## **RESPONSE TO REQUEST FOR ADDITIONAL INFORMATION | PRESTONS SSD7155 - MOD 2**

This letter responds to your request for additional information dated 25 October 2017 regarding SSD7155 MOD 2.

SCALE		
1:150		
DRAWN	CHECKED	PLOT DATE
	DV	02.11.17
PROJECT NO.	DRAWING NO.	REVISION
H8-16040	L503	E

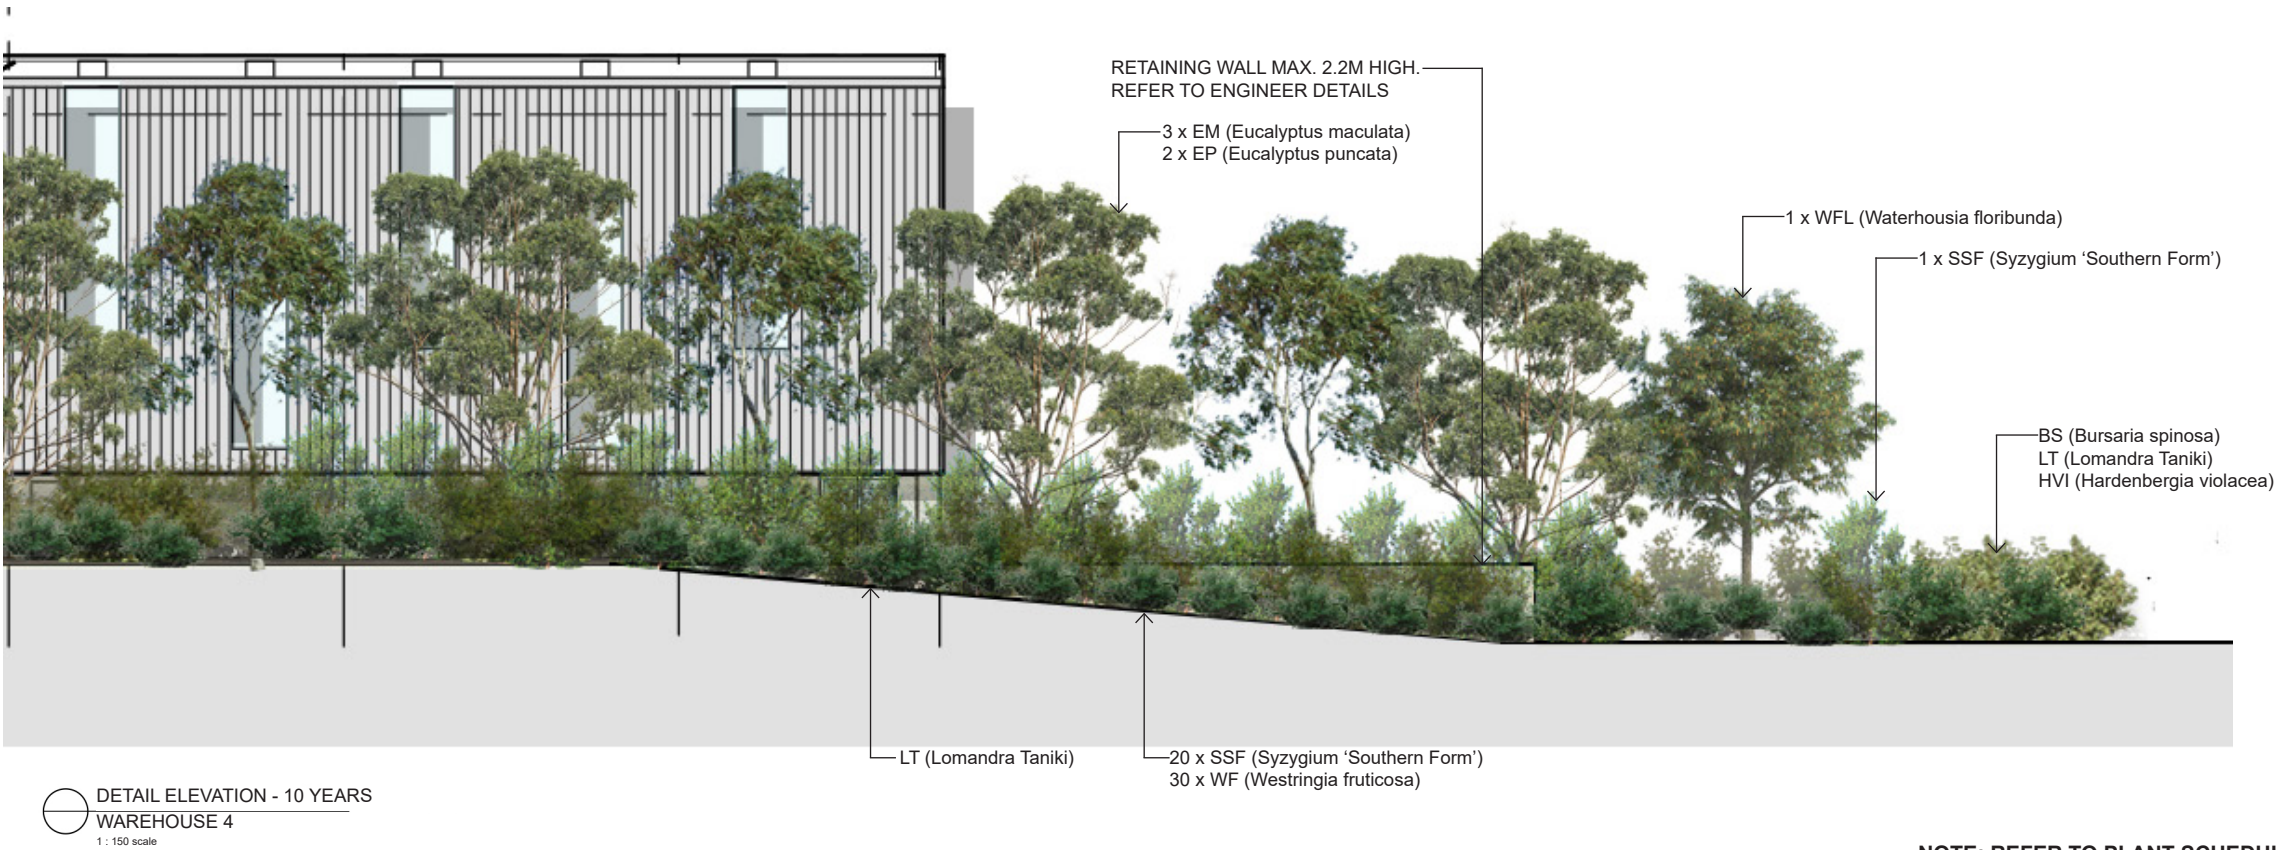
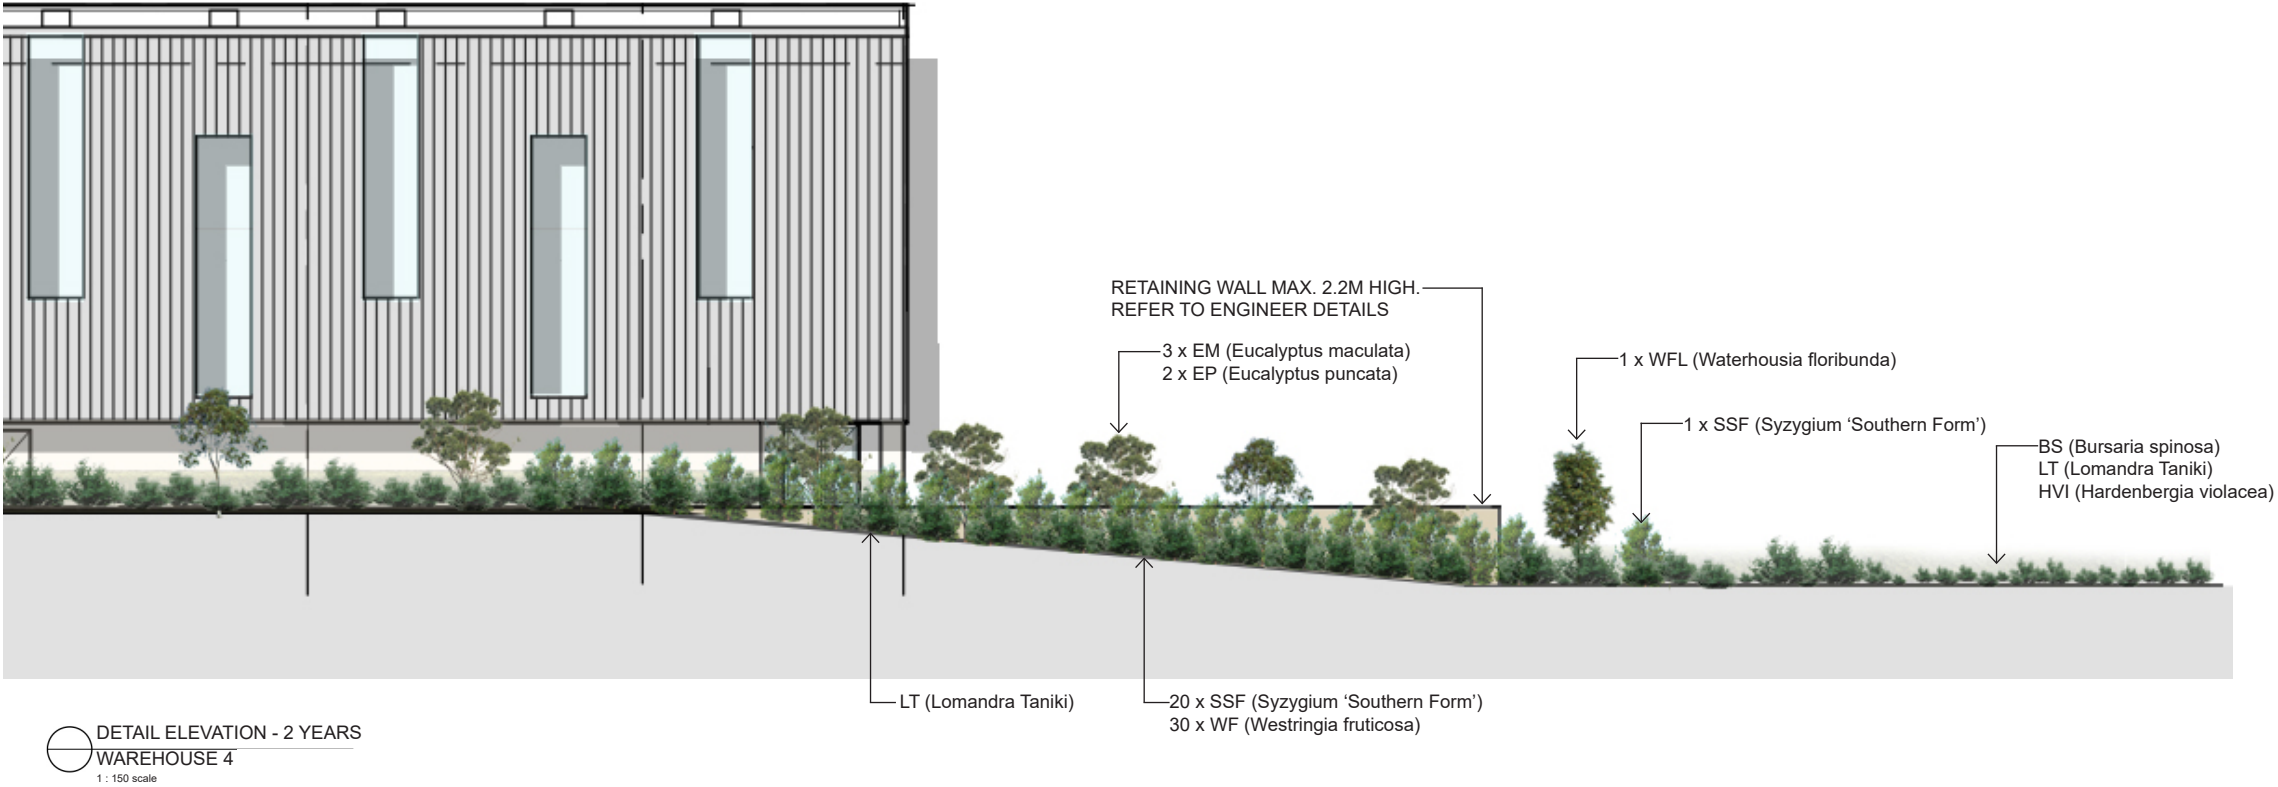
Matter	Response
	<i>ancillary office elements and it is noted that the size of the proposed ancillary office elements is not inordinate.</i>
<b>Landscaping</b>	
Please revise Drawing No. L502 (Rev. D) dated 21 August 2017 prepared by Habit8 to demonstrate that this retaining wall will be appropriately screened by landscaping.	Refer to Drawings L502 Rev E and L503 Rev E which illustrate the retaining wall and the landscape screening.
<b>Architectural Plans</b>	
Please provide a revised building floor plan (Drawing No. A 241 (C)) for Warehouse 4 which shows that the Warehouse 4 building will be a warehouse with ancillary office.	Refer to Drawing Warehouse 4 Building Floor / Roof Plan S96-A241 Issue D which revises the floor plan as per this request.
<p>Please revise the development statistics summary provided in the architectural plans to:</p> <ul style="list-style-type: none"> <li>• Delete references to the Sport and Recreation Facility in Warehouse 4 and specify this as warehouse area; and</li> <li>• Delete reference to car parking for the volvo site.</li> </ul>	The development statistics summary has been updated accordingly.
